Statement of Common Ground with the Environment Agency (draft)

Revision **23** (tracked)

October 2025

- 1.1.1 This Statement of Common Ground (hereafter referred to as the 'SoCG') has been prepared to support the Examination of the Development Consent Order (DCO) application (the 'DCO Application') for Peartree Hill Solar Farm (the 'Proposed Development').

Figure 3.6: Indicative Culvert Crossing Points

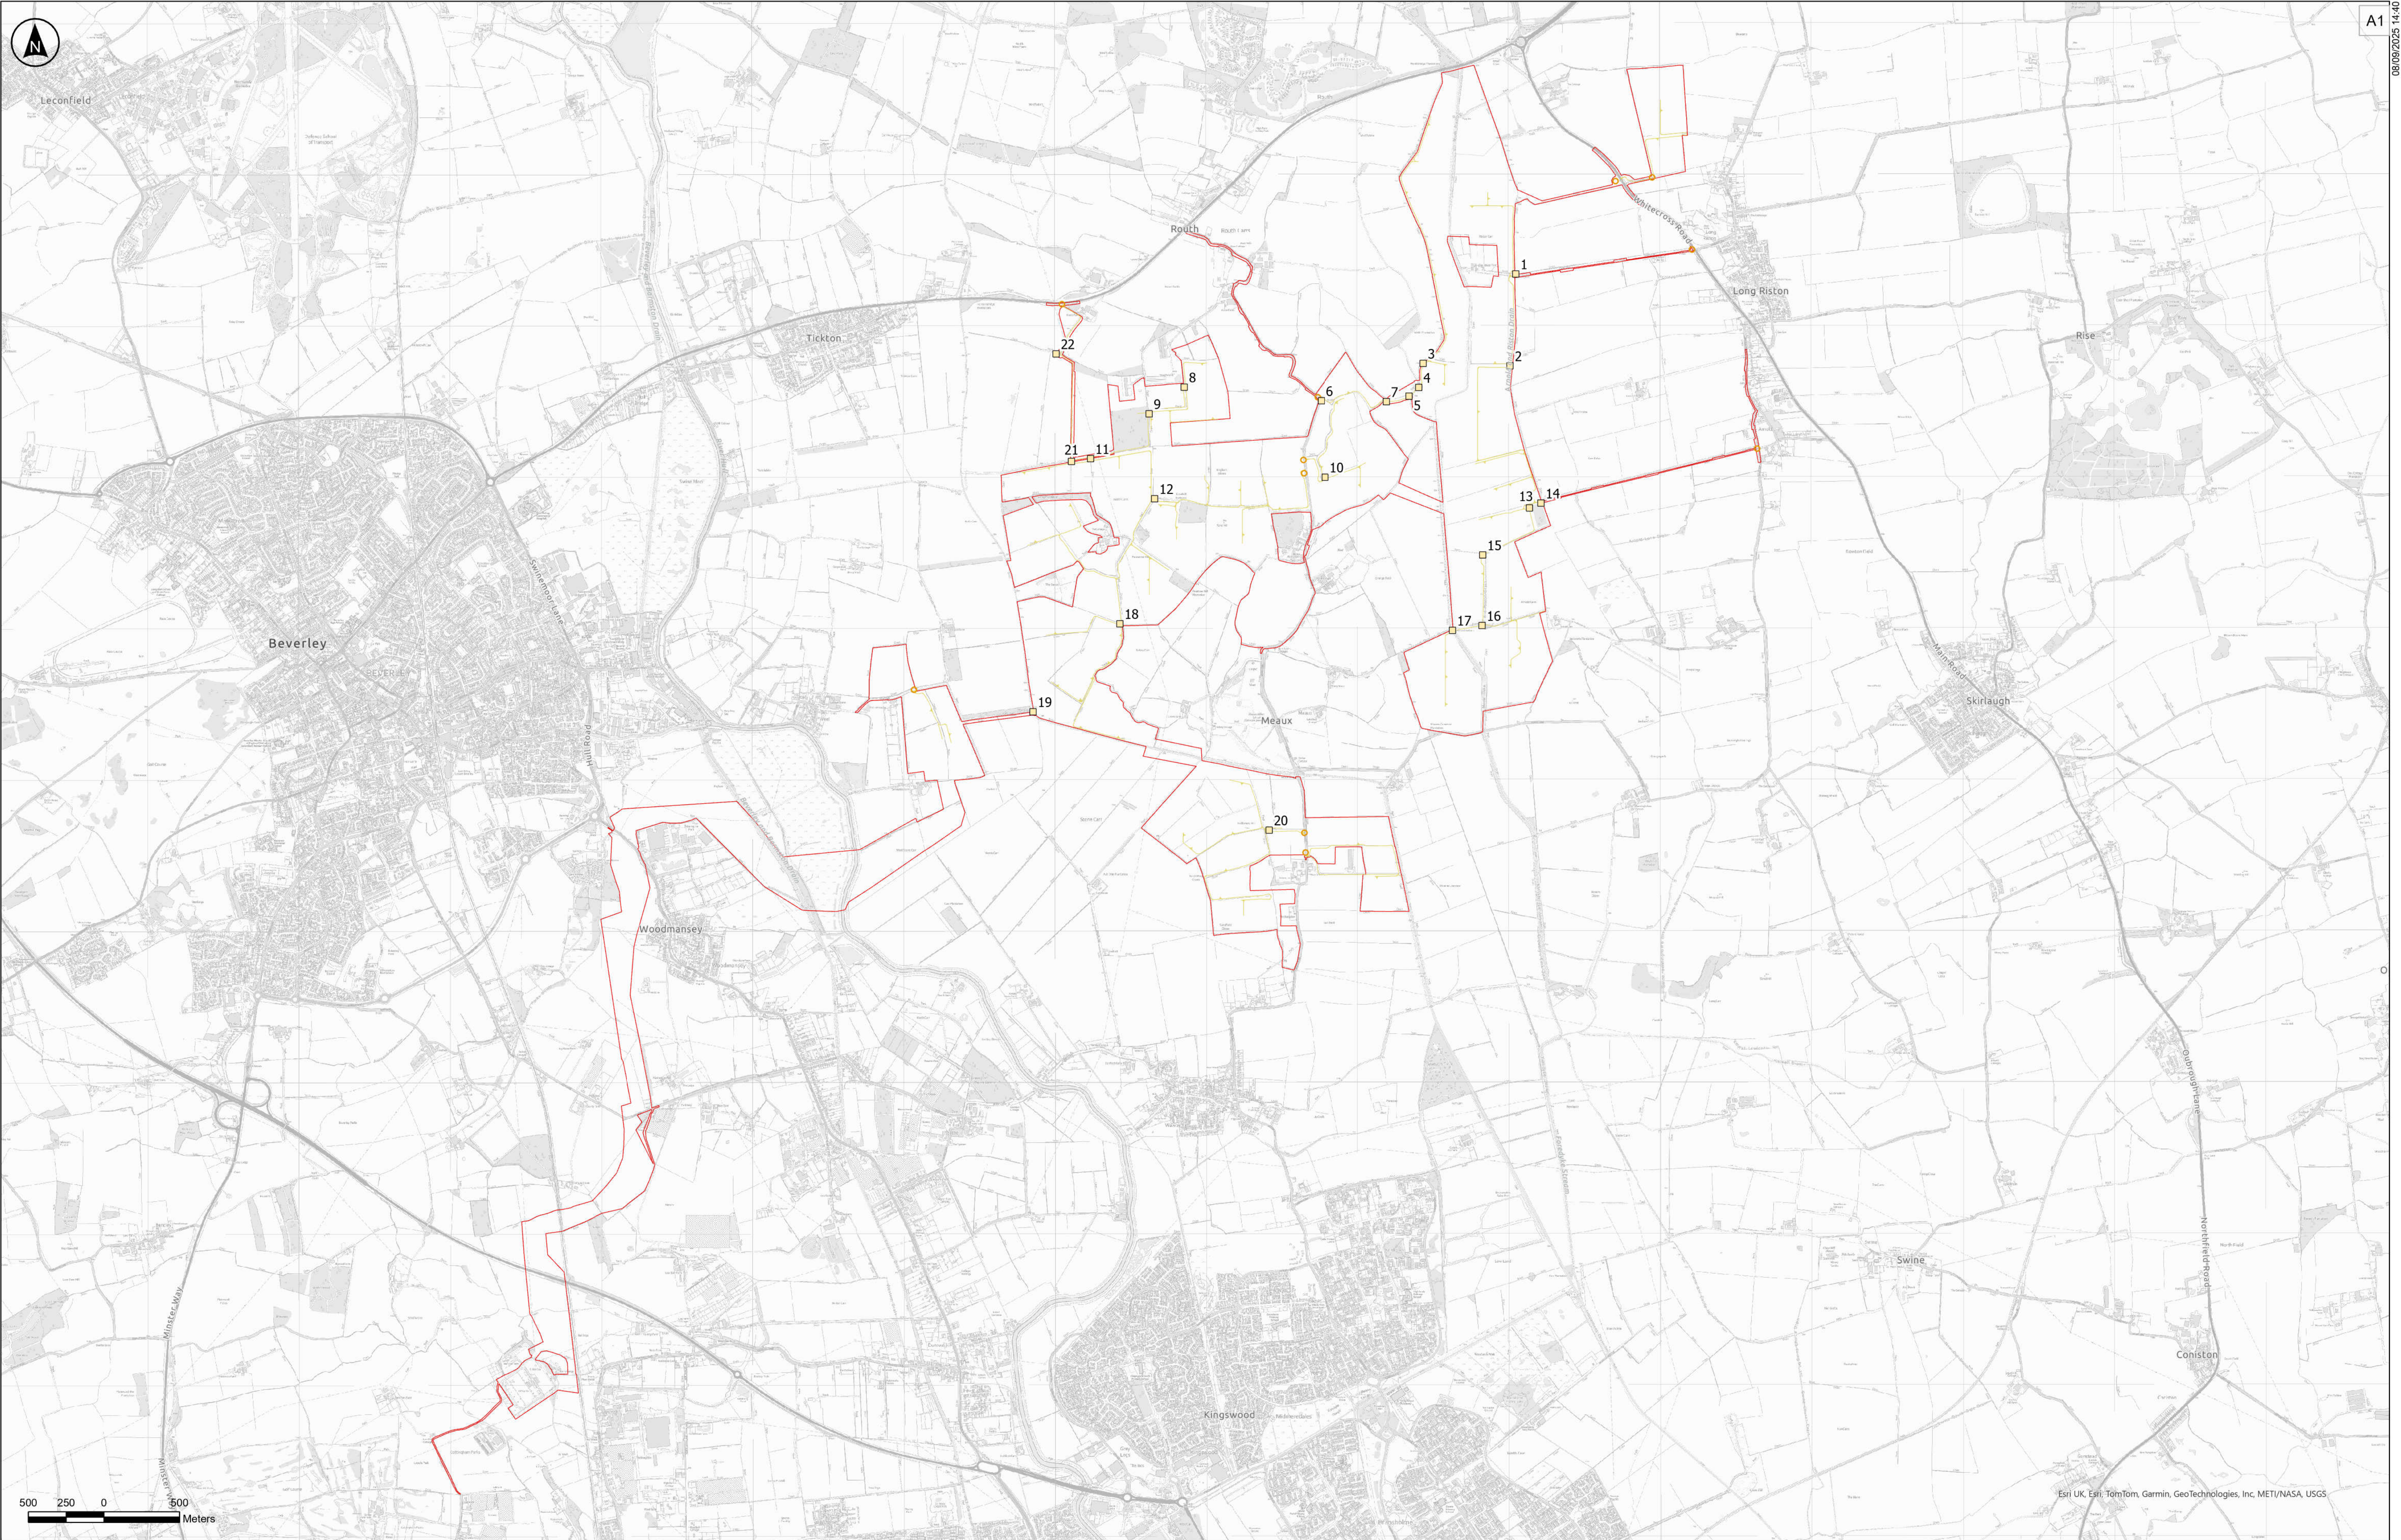
Ref	Topic	Environment Agency's Position	Applicant's Position	Status
EA22	Waste Management Strategy <i>Waste</i>	In their relevant representation [RR-005] (Appendix C), the Environment Agency indicates that it is satisfied with the Applicant's approach to waste management.	The Applicant welcomes this response. Waste management measures are set out in the relevant management plans, including the Outline Operational Environmental Management Plan [EN010157/APP/7.3 Revision 2] , Outline DEMP [EN010157/APP/7.4 Revision 2] and Outline Site Waste Management Plan [APP161] .	Agreed
Geomorphology				
EA23	Use of Culverts <i>Hydrology and Flood Risk</i>	<p>In their Comments on the Deadline 1 Submissions [REP2-153] (EA06), the Environment Agency reiterated its request that the Applicant should avoid the use of culverts wherever possible. The Environment Agency welcomes the Applicant's intention to utilise existing culverts or bridges where possible and that for the purposes of the assessment it has been assumed that all existing crossings will require a new culvert structure.</p> <p>The Environment Agency advises that if any existing box or pipe culvert crossings are found to be unsuitable, they should be upgraded to a portal/3-sided/arch culvert or to a larger box culvert with mammal ledge and be of a</p>	<p>This response is noted and as per the Applicant's Response to Relevant Representations [REP1-071], the choice of crossings is subject to detailed surveys and investigations. The preferred method will be agreed with the Environment Agency at the detailed design stage via the Protected Provisions in Part 4 of Schedule 12 to the Draft DCO [EN010157/APP/3.1 Revision 7]. Box culverts were presumed to be utilised for the purposes of the assessments (such as ES Volume 4, Appendix 5.5: Water Framework Directive Screening and Scoping [REP1-030]) to follow a precautionary approach.</p> <p>It is the Applicant's intention to utilise existing culvert crossings and/or bridge structures where possible. For the purposes of the assessment, 20 locations (see ES Volume 3, Figure 3.6: Indicative Culvert Crossing Points [REP2-</p>	Under discussion

Ref	Topic	Environment Agency's Position	Applicant's Position	Status
		<p>size that does not restrict the passage of water. There should be robust (geomorphic) reasons for the use of piped/box culverts.</p> <p>The Environment Agency reiterates that all crossings should be considered on a case-by-case basis following surveys, not just of structural strength, but of habitat and conservation value, including geomorphological activity.</p> <p>In addition, the Environment Agency notes that the cumulative impact of potentially culverting rivers in multiple locations should be considered.</p> <p><u>The Environment Agency indicated via email on 16 October 2025 that it anticipates this matter can be resolved by the end of the examination.</u></p>	<p>093] are assumed to require either the installation of a temporary span bridge or culvert, or reinforcement or widening of the existing culvert/bridge structure. To ensure a worst-case scenario has been assessed, it has been assumed that all existing crossings will require a new culvert structure. It is however expected that following pre-construction structural surveys the number of new culverts required would be lower.</p> <p>The crossings over minor watercourses, which are likely to be wet for much of the year, would be facilitated by box culverts. These would be fitted with a mammal shelf and the bed substrate would match that of the watercourse within the vicinity of the crossing.</p> <p><u>The Applicant will continue to liaise with the Environment Agency on this matter.</u></p>
